Our Case Number: ABP-319448-24

Re: Proposed Development of an 8 no turbine wind farm development and associated works on land within the townlands of Clonmellon, Kilrush Upper, Kilrush Lower, Newtown, Ballinlig, Carnybrogan, Cavestown and Rosmead, County Westmeath and Galboystown, Co. Meath. (www.knockanarraghwindfarmsid.ie)

ABP Ref. **PA17.319448**
Project: Knockanarragh Wind Farm Development, Co. Westmeath and Co. Meath
Applicant: Knockanarragh Wind Farm Limited

Re: **Submission in relation to a Section 37E application for permission for:**

Figure 12-1: Designated Cultural heritage assets

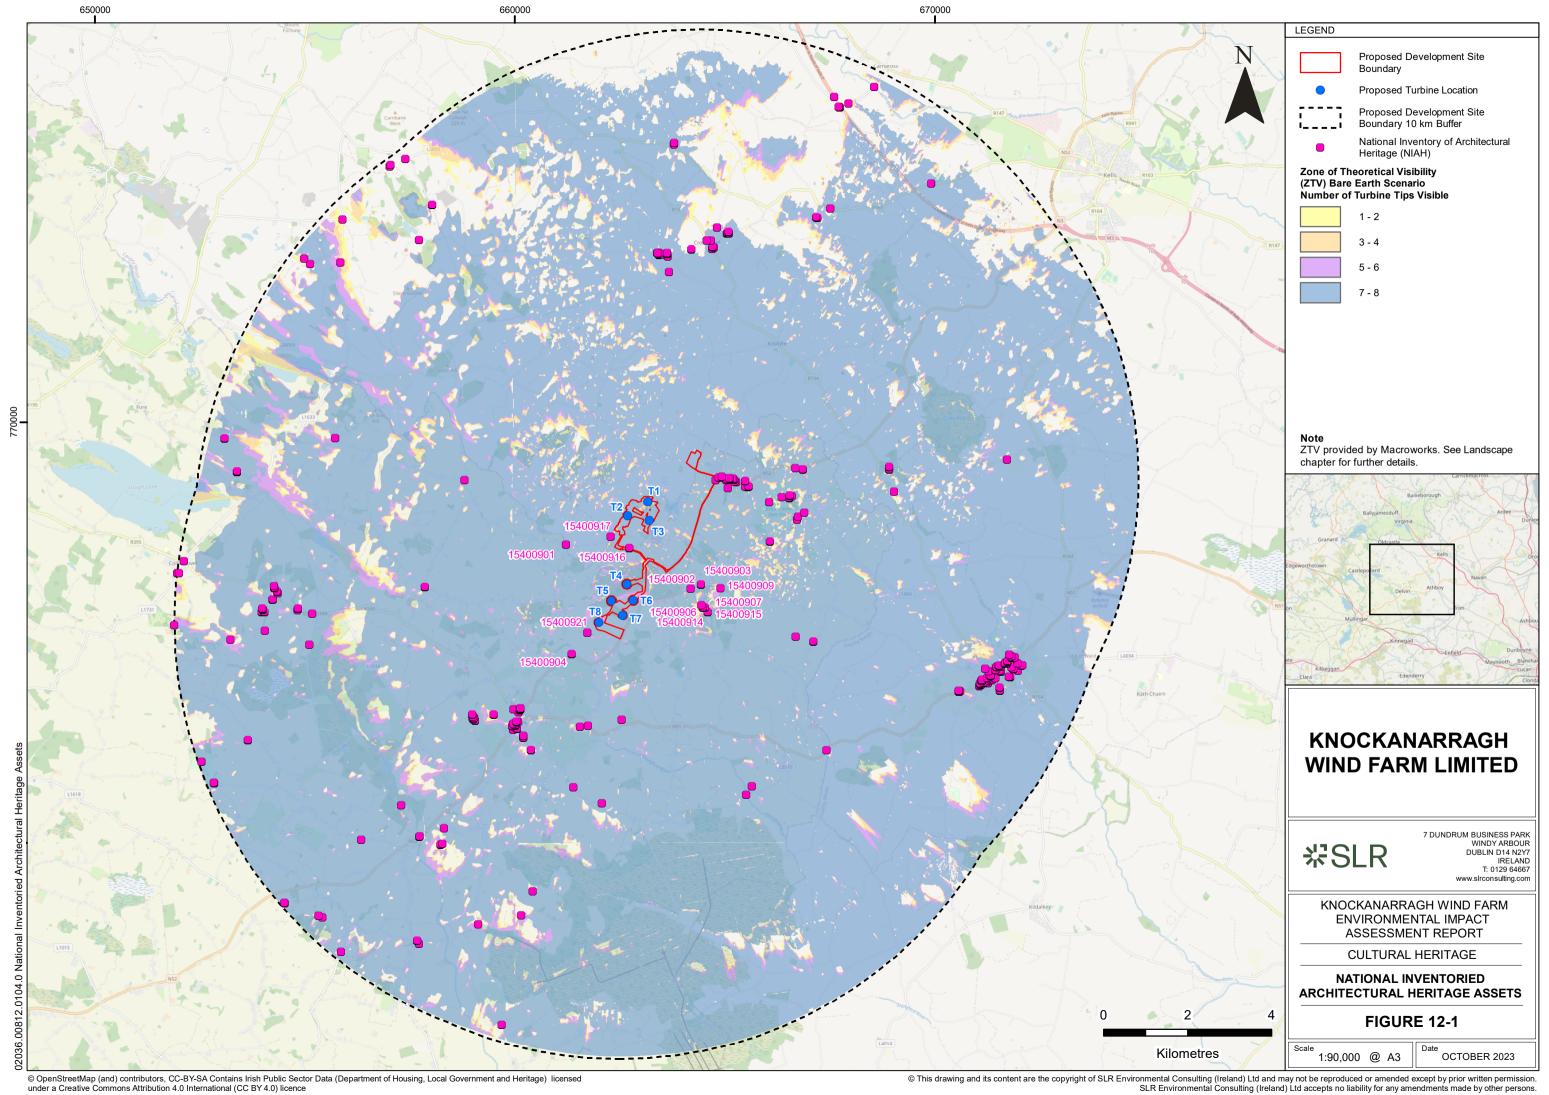
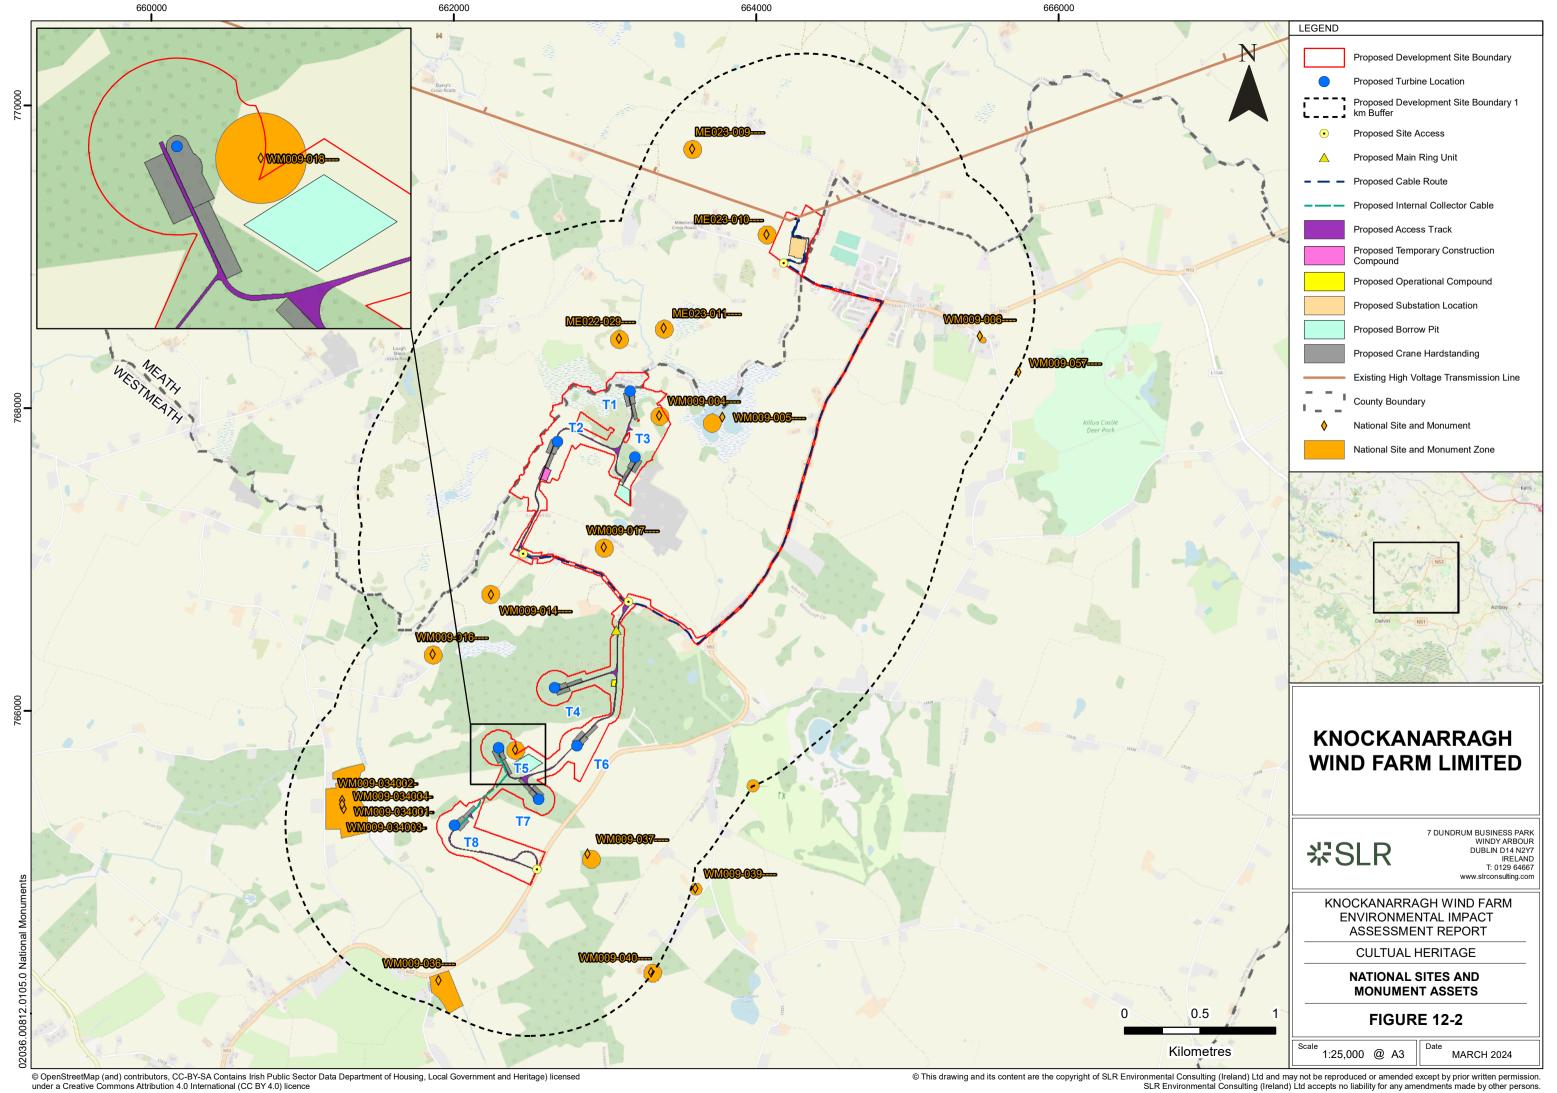
Local sites of heritage value are discussed in detail, however, we note that the significant heritage landscapes of Loughcrew and Fore Abbey are not mentioned even in the baseline context.

Often the environmental, landscape and visual setting of tourism sites is as important to appreciation and experience of visiting such attractions themselves. This is especially the case for features of cultural heritage significance where there is a relationship to the surrounding landscape. In this regard it is considered that the assessment in Chapter 12 should have addressed the character, nature and significance of the landscape as a setting for Loughcrew and Fore Abbey.

We would also consider that the assessment of the impact of the proposed development on local sites of heritage value – e.g. Rosmead House and Triumphant Arch (*‘Smiling Bess’*), Ballinlough Castle and other local heritage sites – underrepresents the actual significance of effects that are likely to be experienced.
